March 5, 2018

RE: **Boulders Phase 3**
Engineers Certification for Release of Financial Guarantee
Grading and Drainage Plan Stamp Date: 1/28/14
Certification Date: 2/27/18
Hydrology File: B10D001D

Based on the Engineers Certification received on 2/14/18, this project cannot be considered for Release of Financial Guarantee by Hydrology until the following are corrected:

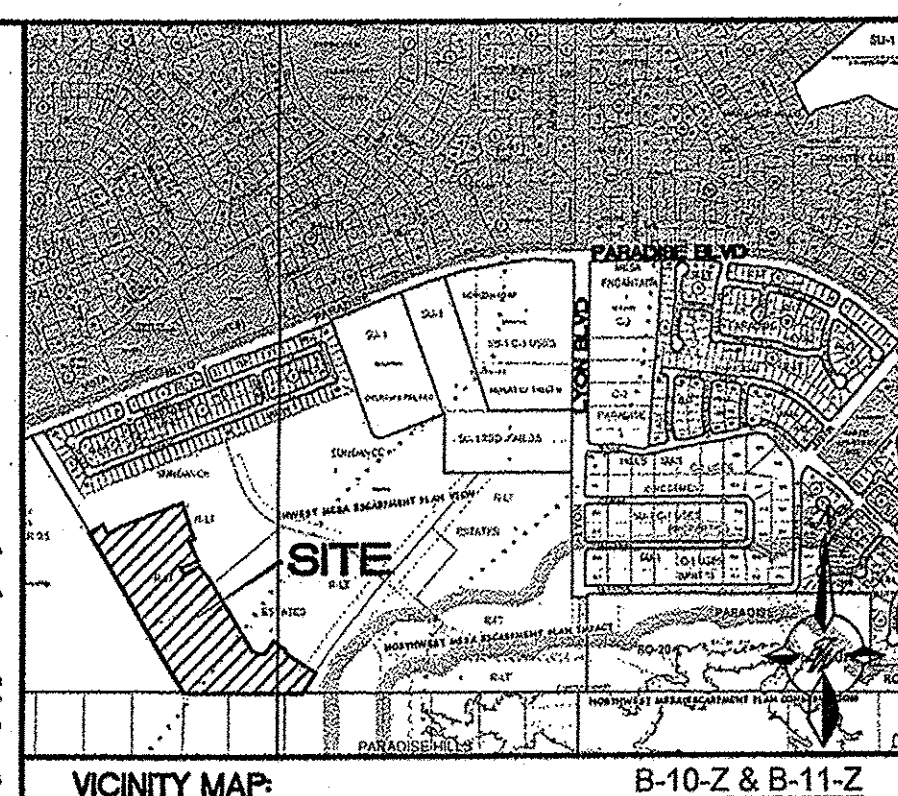
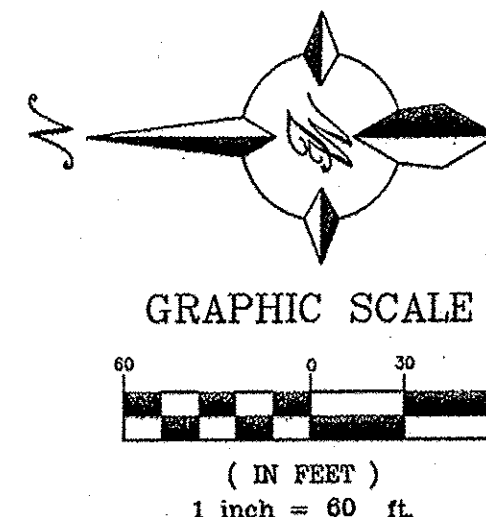
1. The floodwall along the southern edge of the pond need to be backfilled and compacted. It was left exposed and does not tie-in to the berm:

3. The as-constructed pond volume needs to be calculated and certified on the plan.
